TH347-01F04 Addendum to DA Acoustic Report (r5)

North Plot, The Darling Exchange - Addendum to SSDA10 Acoustic Report

This technical memo is an addendum to address the revised design changes and is to be read in conjunction with the original Acoustic Report submitted with the Development Application.

Figure 8.1.1\_Darling Square Loading Areas. Refer TTM Traffic Management Report

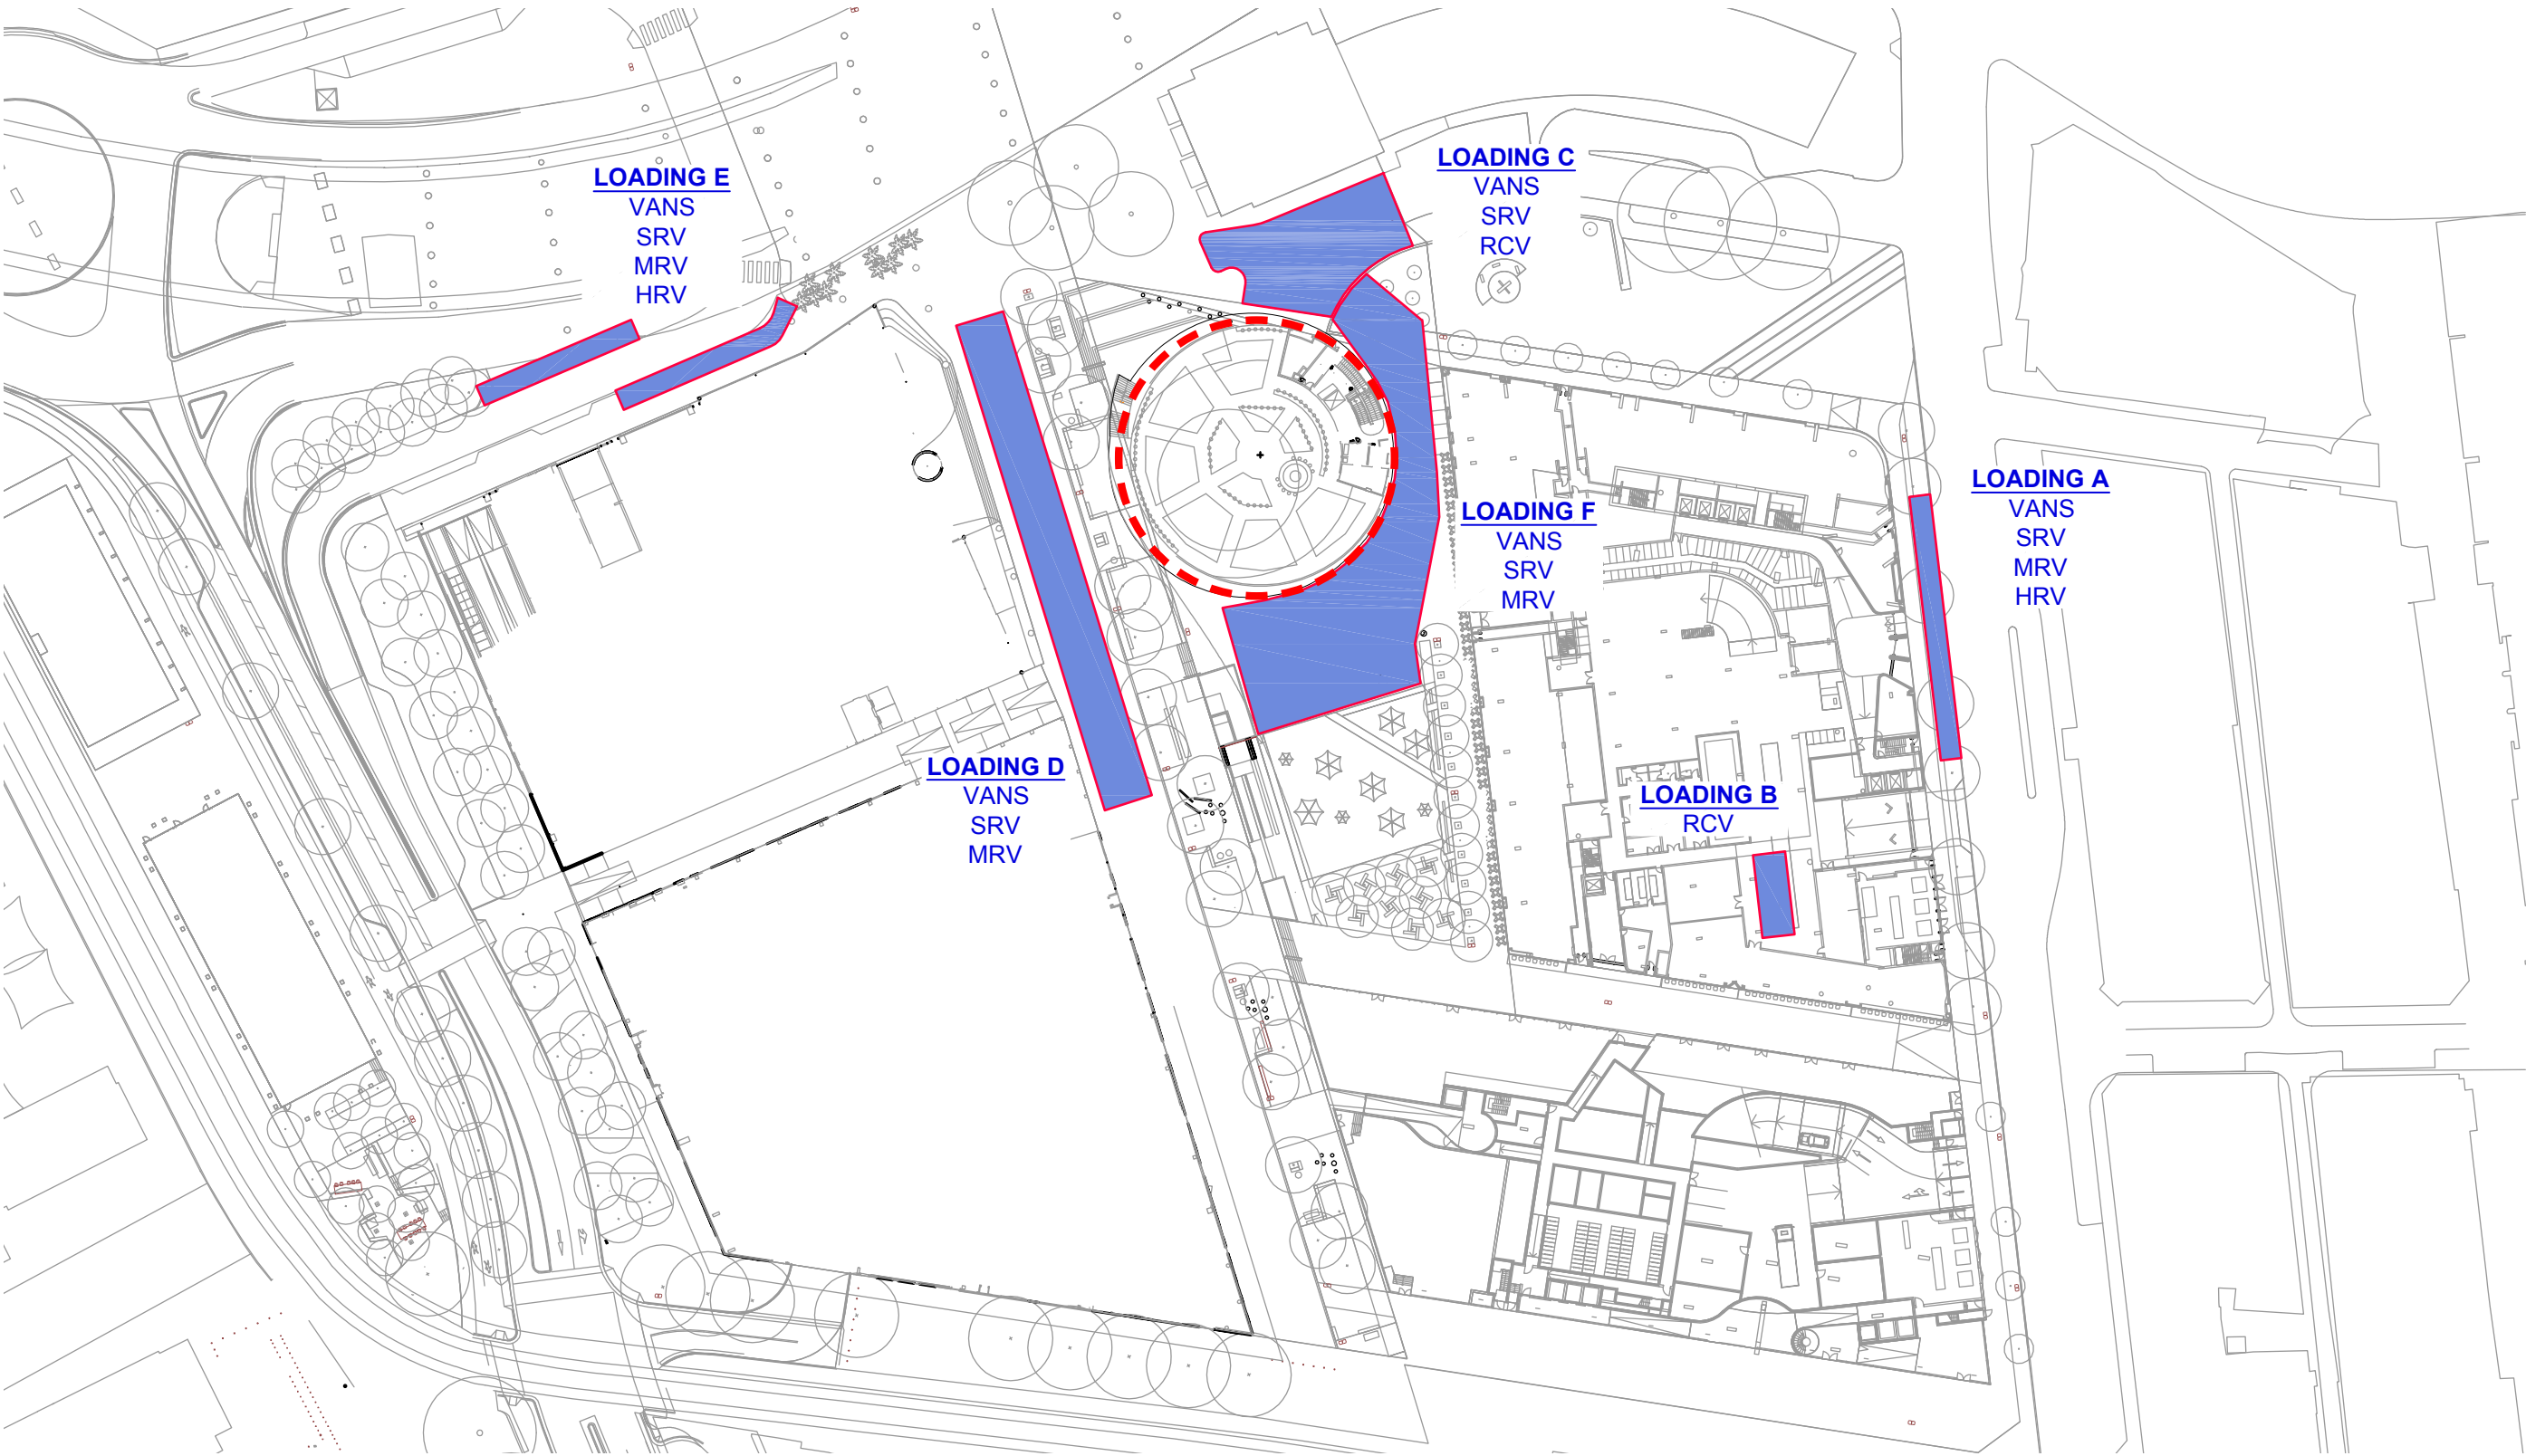
Query: *The Noise and Vibration report (Appendix P) includes a loading matrix that suggest loading times up to 8pm, however, the loading service area assessment suggests a limit of 10pm. Provide confirmation of exact expected loading times, whether any loading is proposed after events ending at 10pm in the square and how the noise from any such loading will be managed/minimised if proposed.*

Response: The loading strategy has been amended since the lodgement of the Development Application. Loading for the North Plot will now be serviced through the North East Plot (Loading area B) with loading for the public domain and events now occurring primarily through the boulevard (Loading Area D) with support via Theatre Access Lane (Loading Area E). This has removed loading zones F and C directly outside the North East Plot and Novotel that were identified in the original report as sensitive with regard to noise sensitive receptors.

As noted in the original report Loading Area D will also need to be managed with regard to potential impacts within the Darling Square development. In particular, the SW Plot and SE Plot will need to be considered. Medium and large scale events will require future approvals with Place Management NSW (formally known as SHFA). Attached to the detailed application on an event by event basis, there will be a specific Plan of Management provided which will deal with key acoustic mitigation measures for event types. A general Plan of Management is provided with this RTS that recommends bump out for events finishing after 10pm to occur the next morning to minimise impact on surrounding properties.

Figure 3.5.3_The core is rotated 22.5 degrees from original position to the south

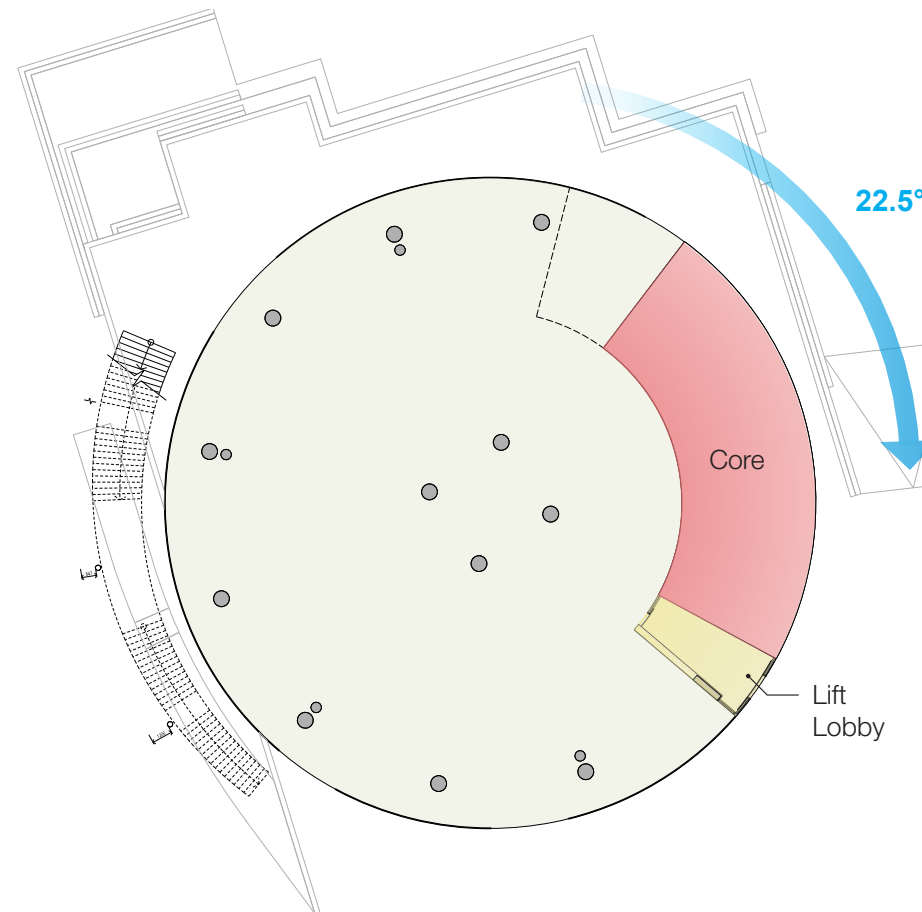
In addressing the response to submissions items list above, the level 5 Bar / Restaurant has undergone additional acoustic modelling to assess the noise impacts within the amended design. The noise impacts predicted to comply with the established noise incorporating the recommendations and operational noise management strategies outlined below.

Despite the core being rotated towards the Novotel Rockford Hotel, the revised design proposes to install 1800mm high balustrade glazing around the outdoor terrace area, providing additional noise reduction through acoustic shielding. The original assessment assumed no balustrade between the accessible outdoor terrace and nearby noise-sensitive receivers. The revised balustrade height is beneficial to the acoustic performance of Level 5 Bar/Restaurant.

Figure 4.5.2_Proposed Level 5 Bar/Restaurant

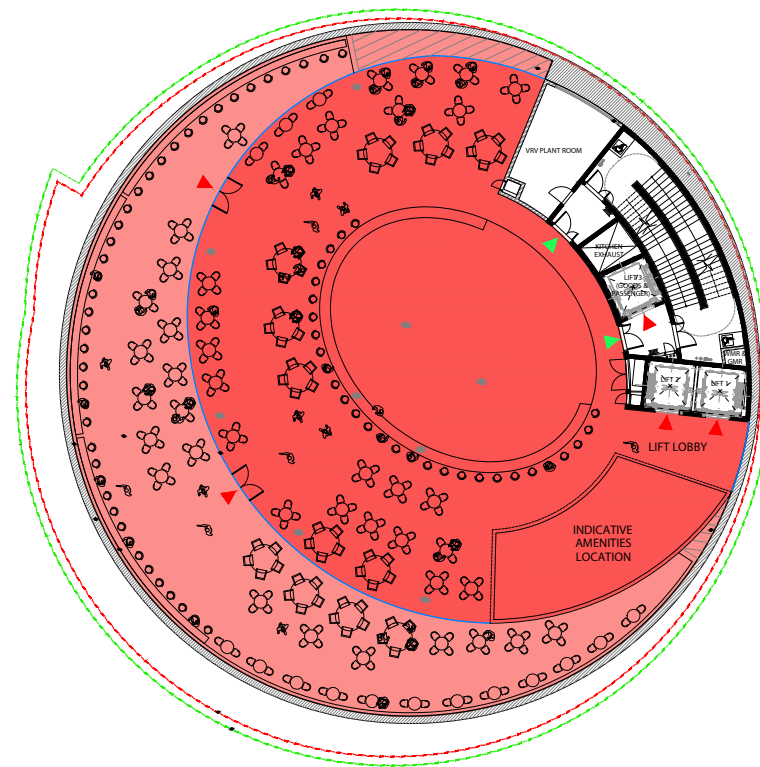
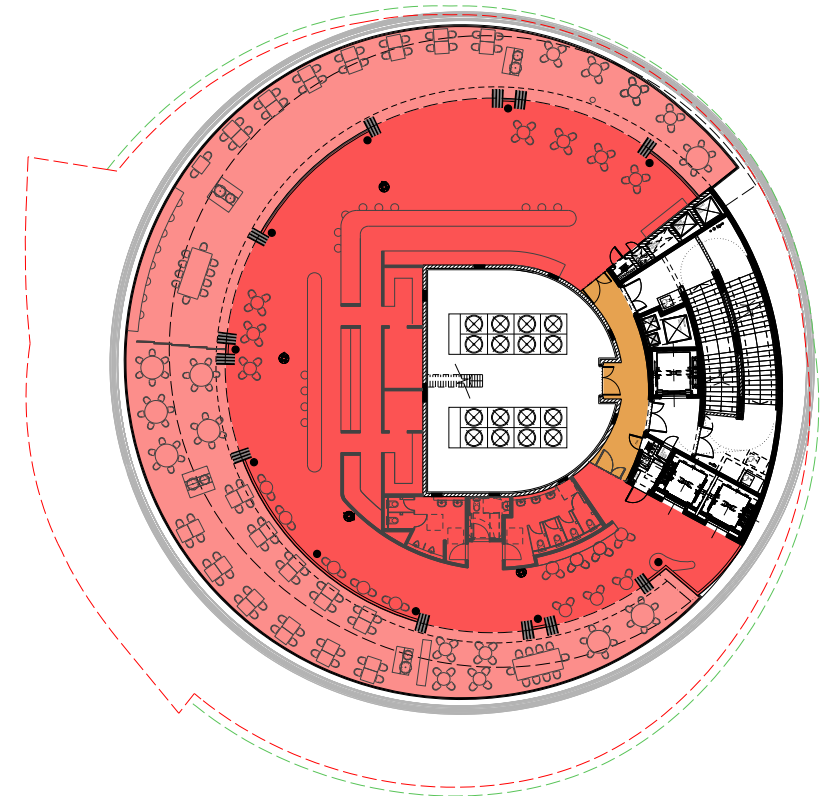
SHFA Query: It is noted that the proposal includes a rooftop restaurant and bar in addition to community facilities and markets. This appears to be inconsistent with the original purpose of the building on the North Plot and inappropriate to the location given.

The area and patronage on level 5 has been reduced through design improvements relating to the heating and cooling for the building. This includes the removal of VRV plantrooms located on each floor level with a centralised chiller plantroom on Level 5 and AHU plantroom on Level 1. The Level 5 plantroom perimeter is fully enclosed by the proposed development, shielding the chiller units from any nearby noise-sensitive receivers located at equal or lower height. The design change from level by level VRV plantrooms to a centralised chiller located at the roof level is therefore an improvement to the acoustic performance when assessed at the nearby sensitive receivers.

The indicative fit out for the Level 5 Bar / Restaurant has been updated and patron numbers reduced due to the centralised plant room / lifting strategy and reduced floor area with a maximum of 280 external and 120 internal patrons.
